# EAGLEVIEW SUBDIVISION GRADING AND EROSION CONTROL PLAN

DESIGNED BY: MJK  
DRAWN BY: MJK  
CHECKED BY: KKK  
DATE: 12/23/2022

EAGLEVIEW  
EL PASO COUNTY, COLORADO  
GRADING AND EROSION CONTROL PLAN  
COVER SHEET - GEC PLAN

K:_COS_Civil\196288000_Eagleview\CADD\PlanSheets\Early GEC\EG_GEC_INITIAL.dwg Schnelboch, Ryan 12/23/2022 12:24 PM

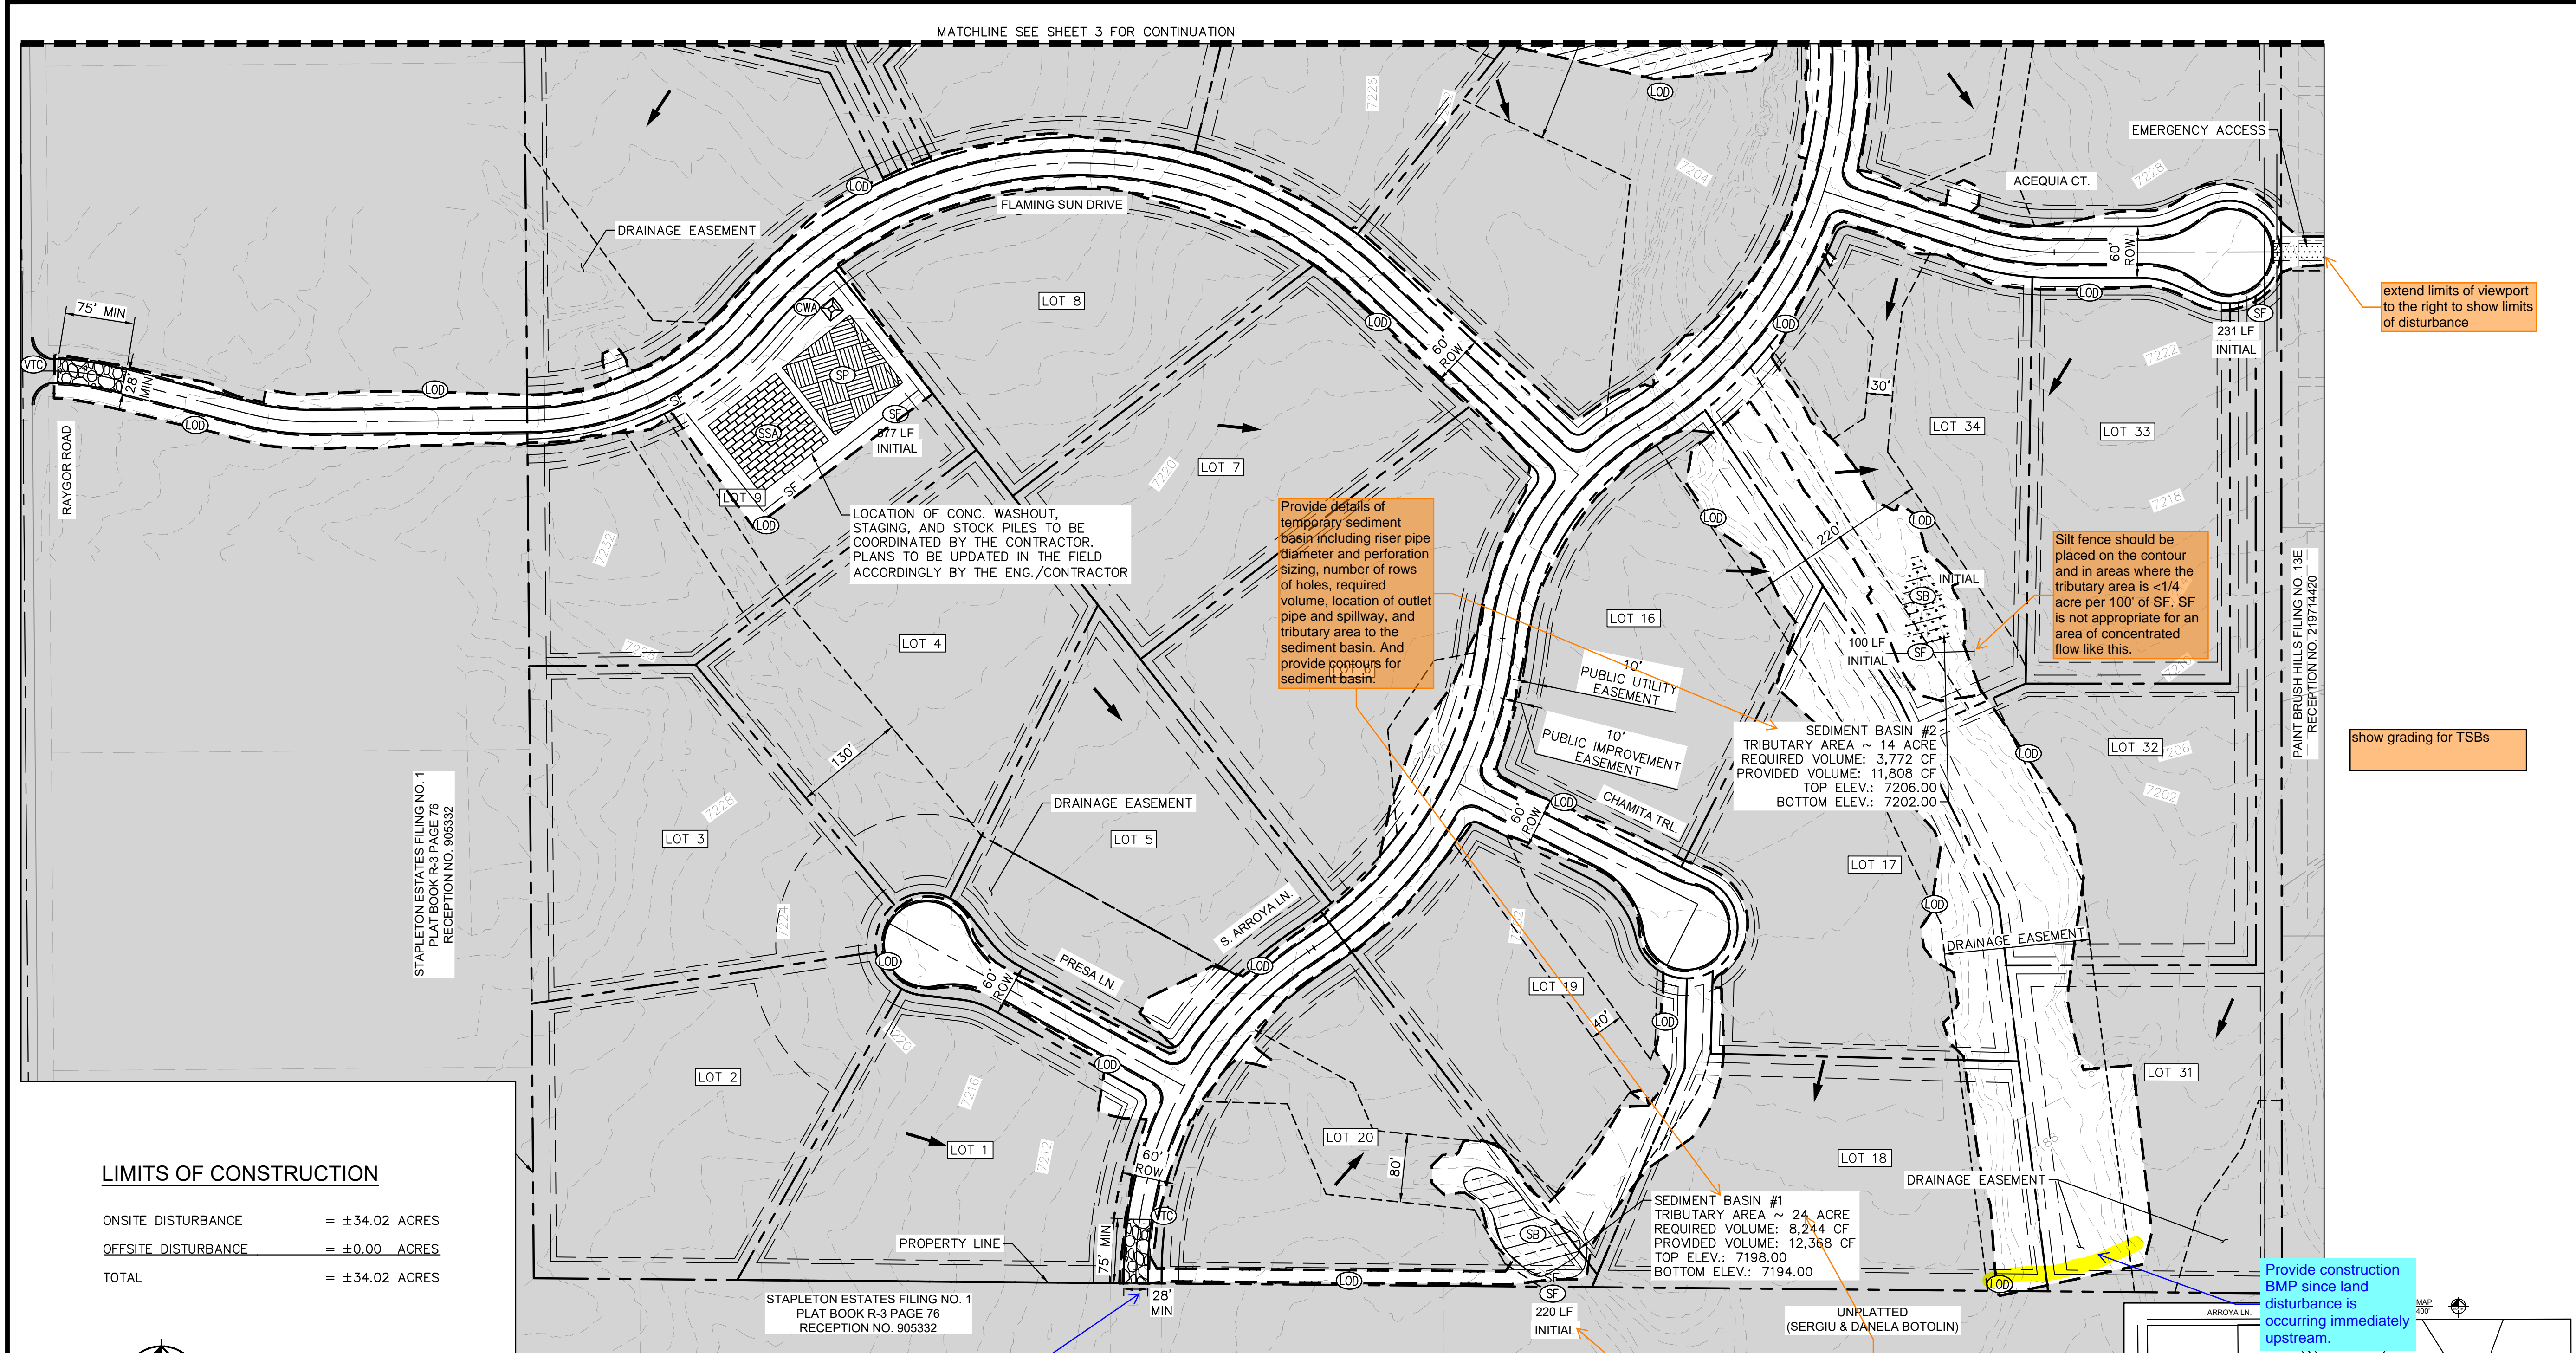
Show the temporary outlet structure location and spillway location.

Correct property line to heavy black line all sheets

SHEET
5

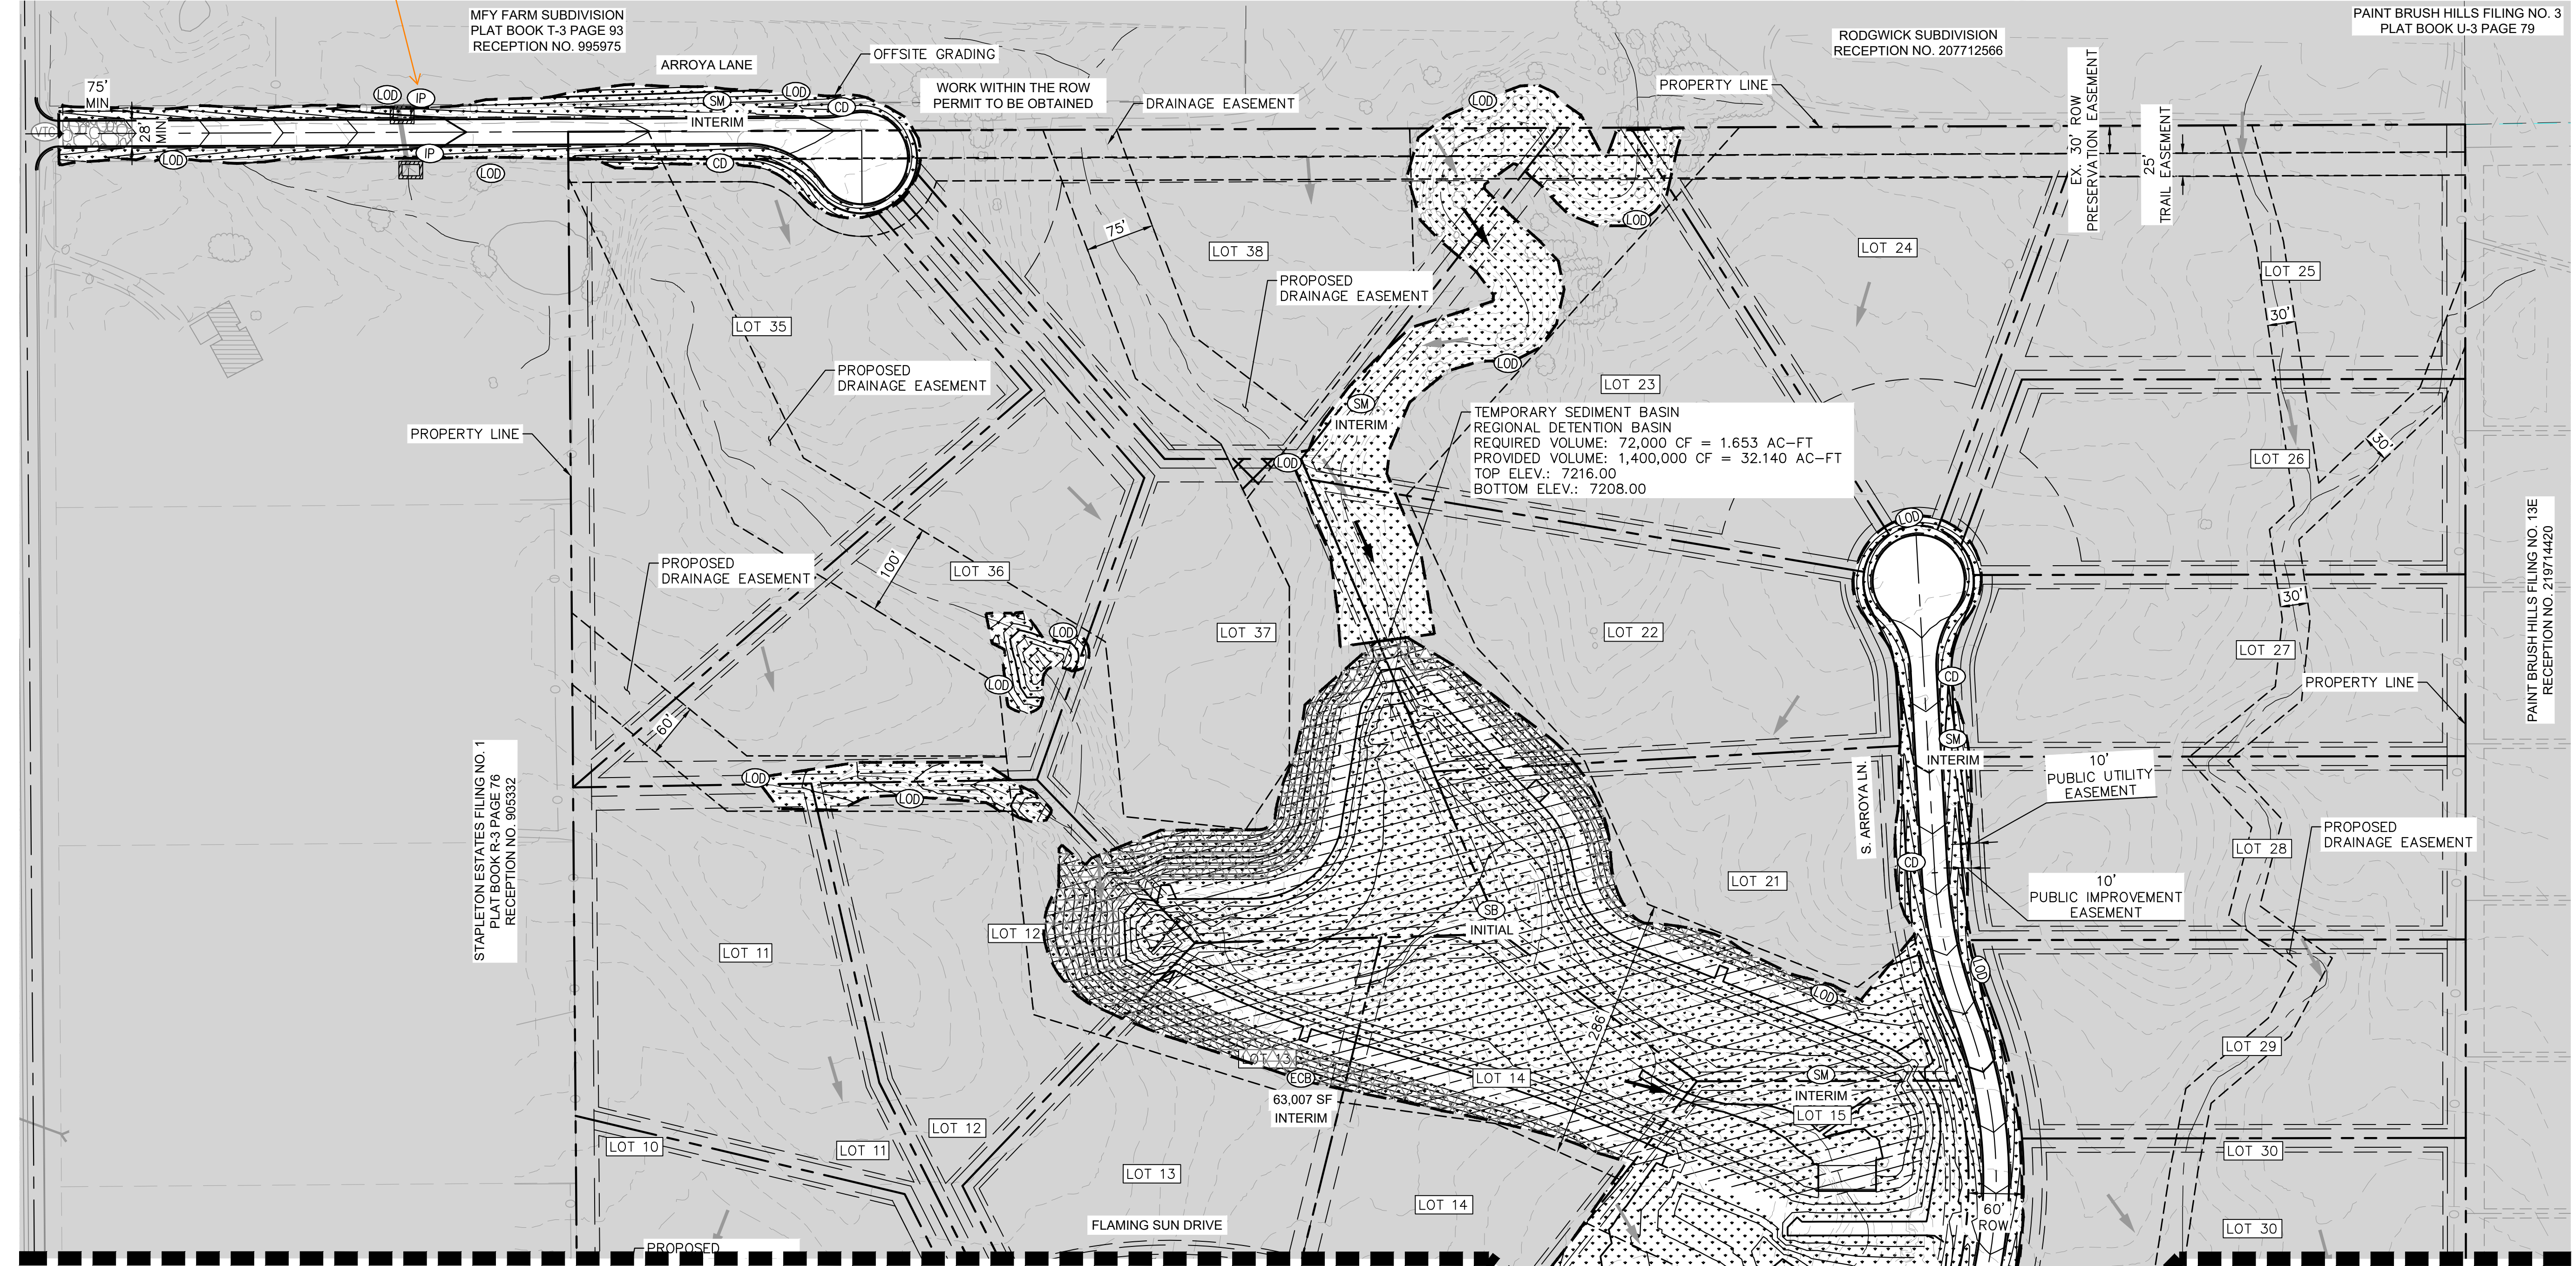
Provide Road name for section
